Project # 1002324

KEN HOVEY agent(s) for MOCHO, OLSON, CHANEY & MOCHO LLP request(s) the above action(s) for all or a portion of Block(s) 4, Tract(s) 7-A, Unit B, **NORTH ALBUQUERQUE ACRES**, (to be known as **VENICE BUSINESS CENTER**, zoned IP, located on BEVERLY HILLS AVE NE, between SAN MATEO BLVD NE and I-25 NE containing approximately 6 acre(s). [REF: 1000447, 1000907] (B-18) **THE SITE DEVELOPMENT PLAN FOR BUILDING PERMIT AND THE SITE DEVELOPMENT PLAN FOR SUBDIVISION WERE APPROVED AND SIGNED OFF BY THE BOARD.**

Agenda Item: 8 Project #: I002324
Application # 02DRB-01741 & 01742

Subject: Venice Business Park

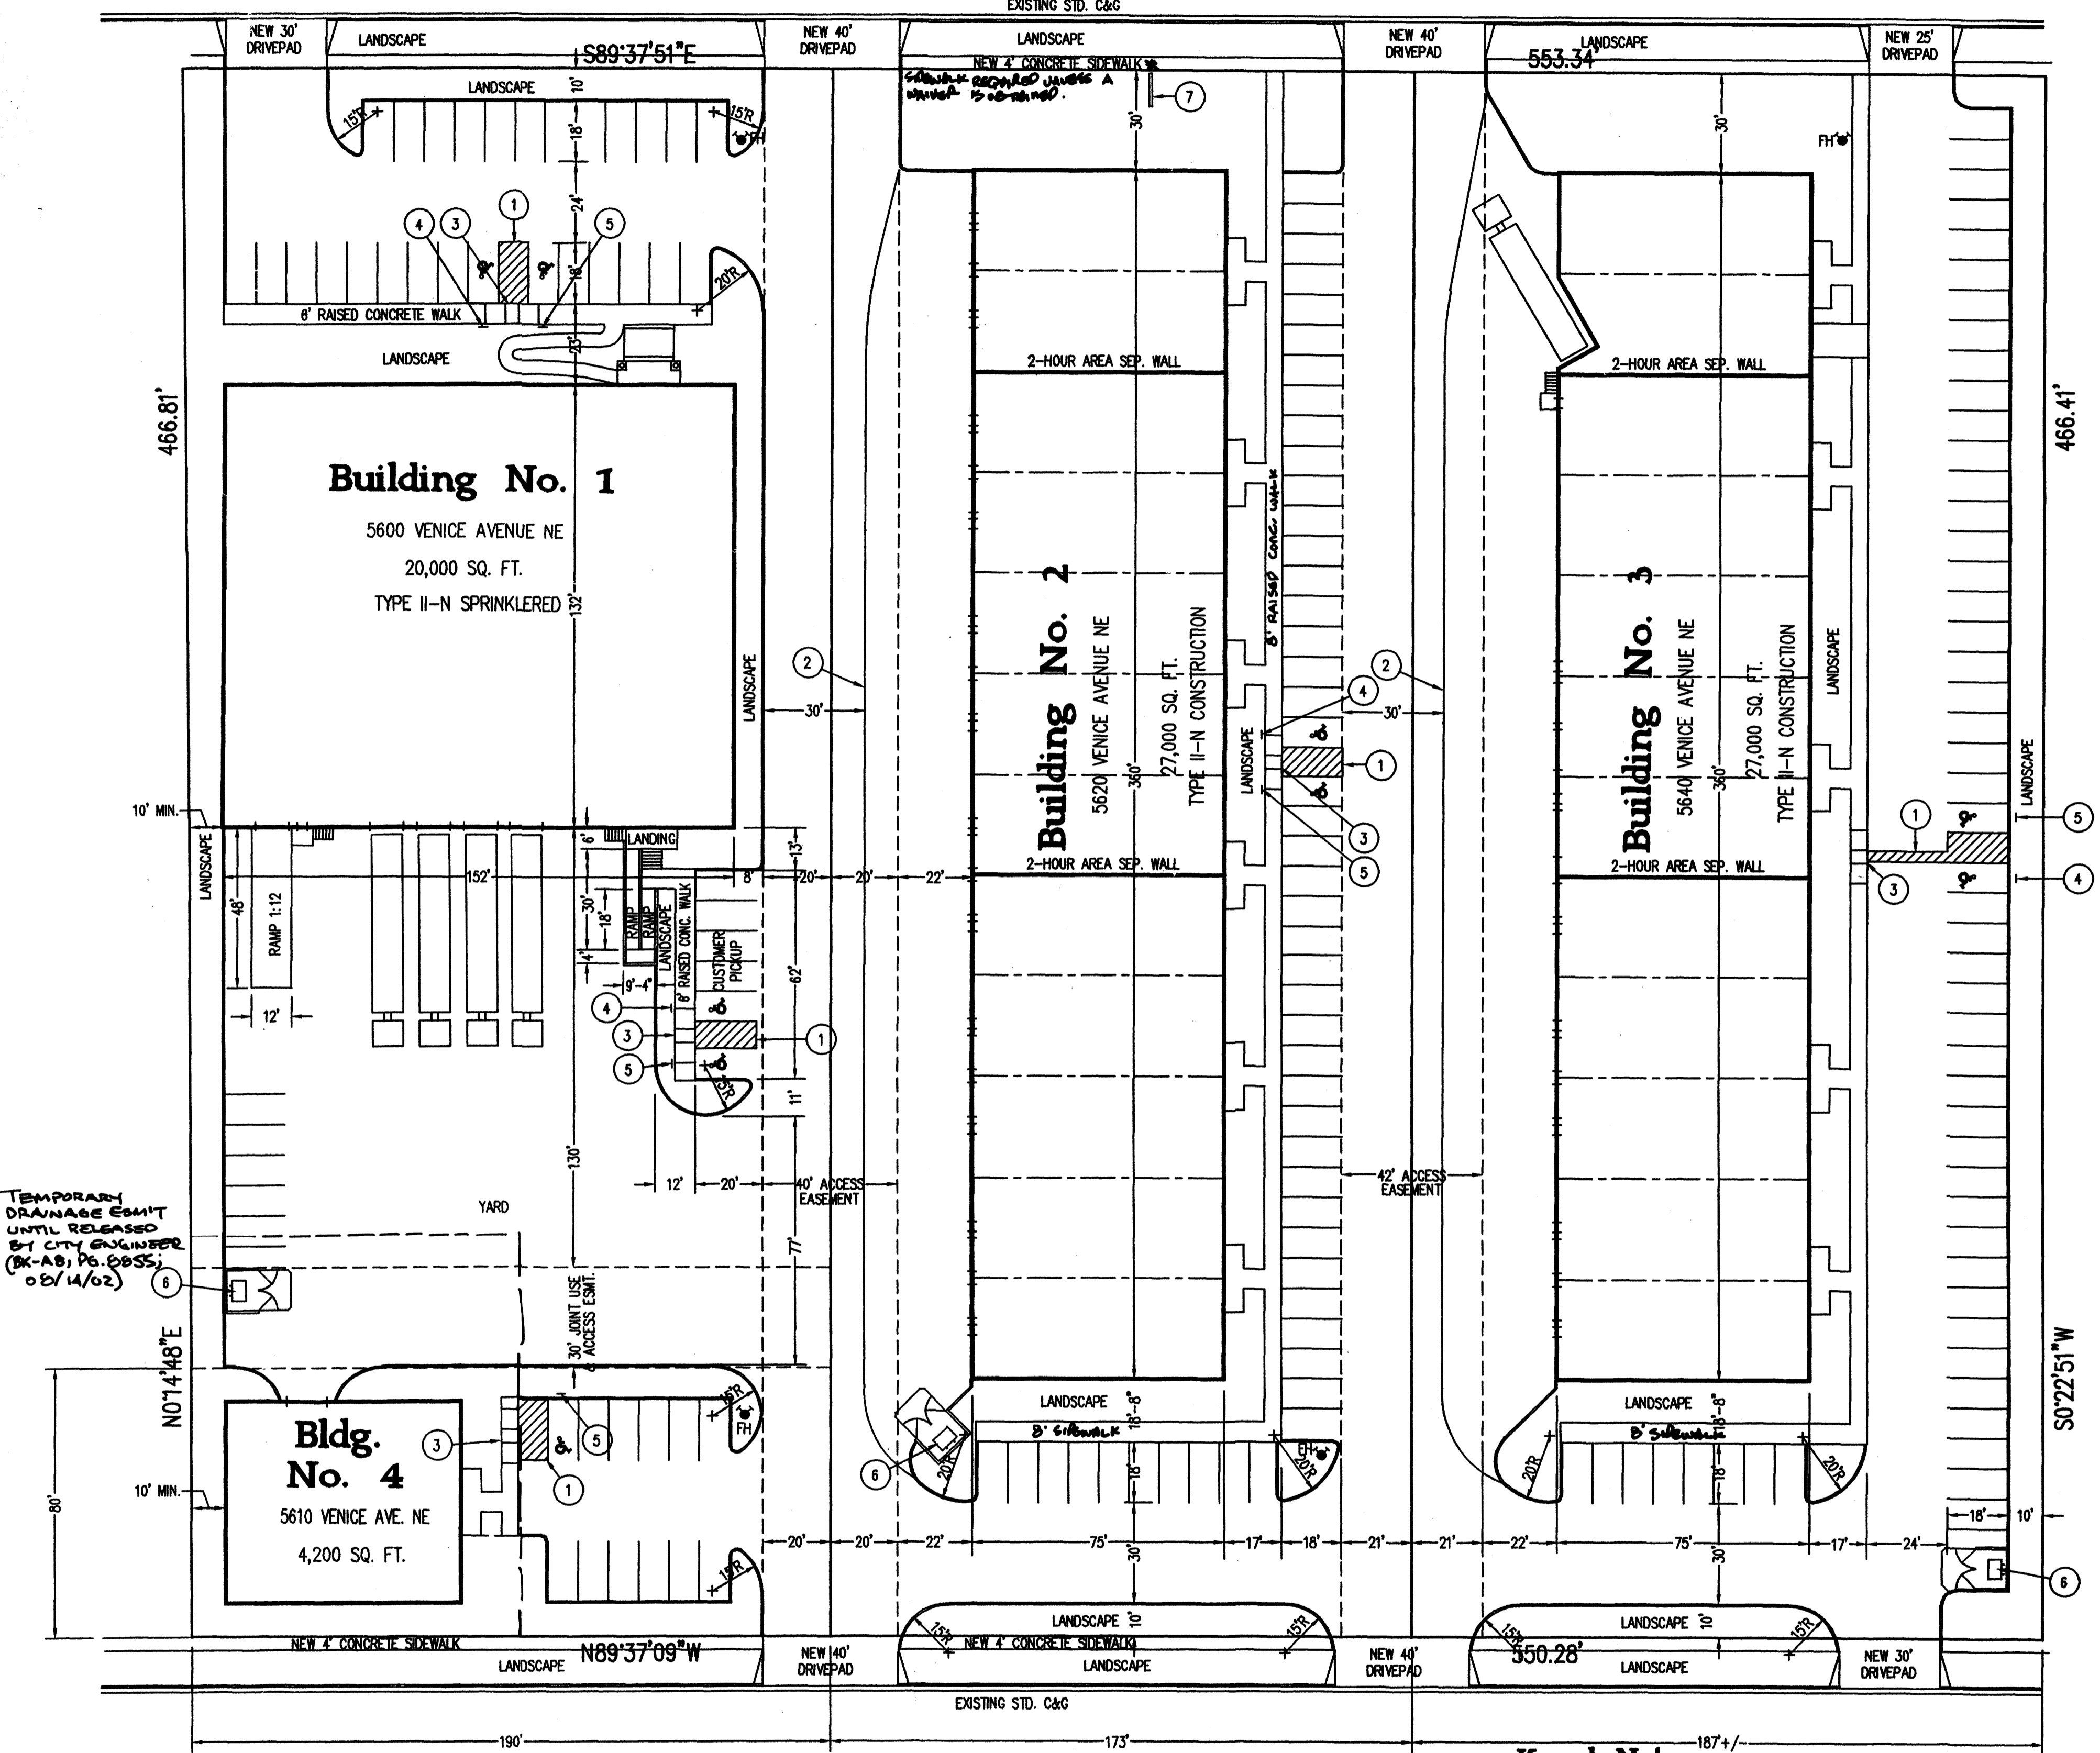
These are the remaining items to be addressed in the SDB for building permit:

1. The handicapped parking spaces for Building 1 should be moved to the spaces closest to the building.
2. According to the recent amendments to the Zoning Code, a sidewalk which abuts a building must be 8 feet wide to ensure at least 6 feet of clear walking area.
3. The text in the landfill disclosure statement is not the required language. We can provide you with the correct language if you wish.

will mark on site plan

**PLAT
FOR
LOTS 7-A-1, 7-A-2 & 7-A-3
NORTH ALBUQUERQUE ACRES
TRACT A, UNIT B, BLOCK 4**

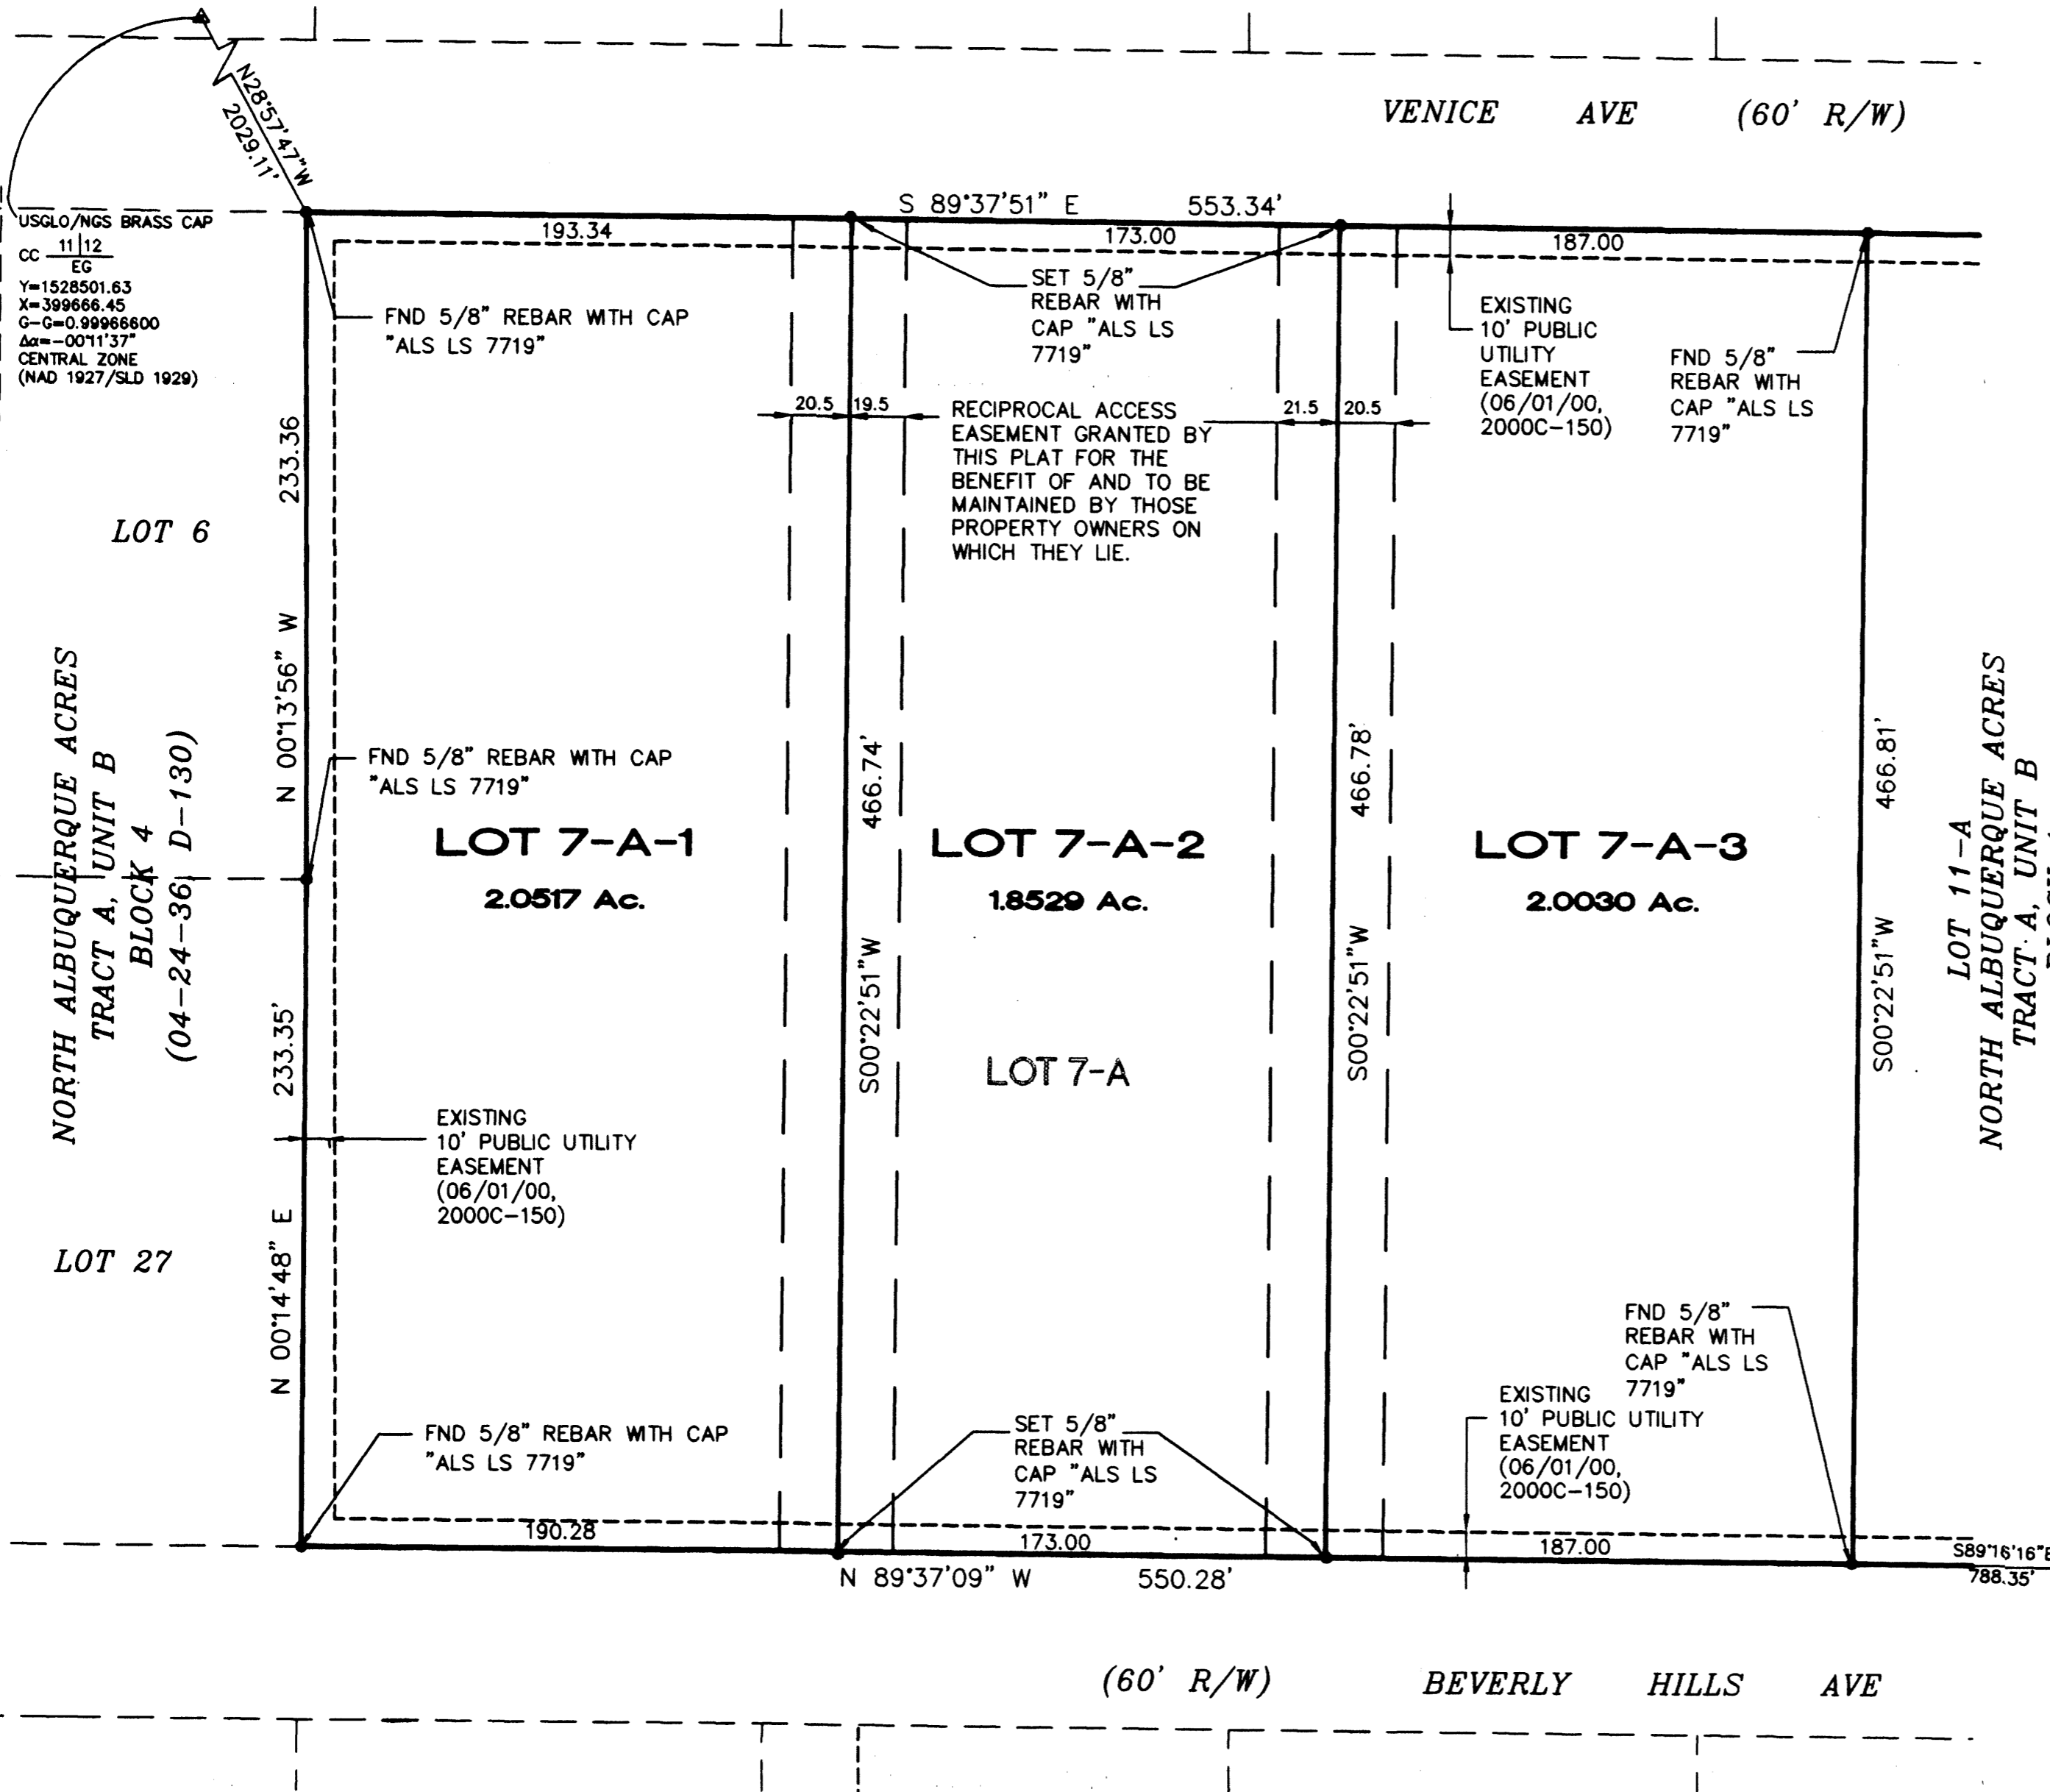
No adverse comments on Site Plan.
 Pond easement must be shown on plat or be released by the City prior to Final Plat signoff by City Engineer.
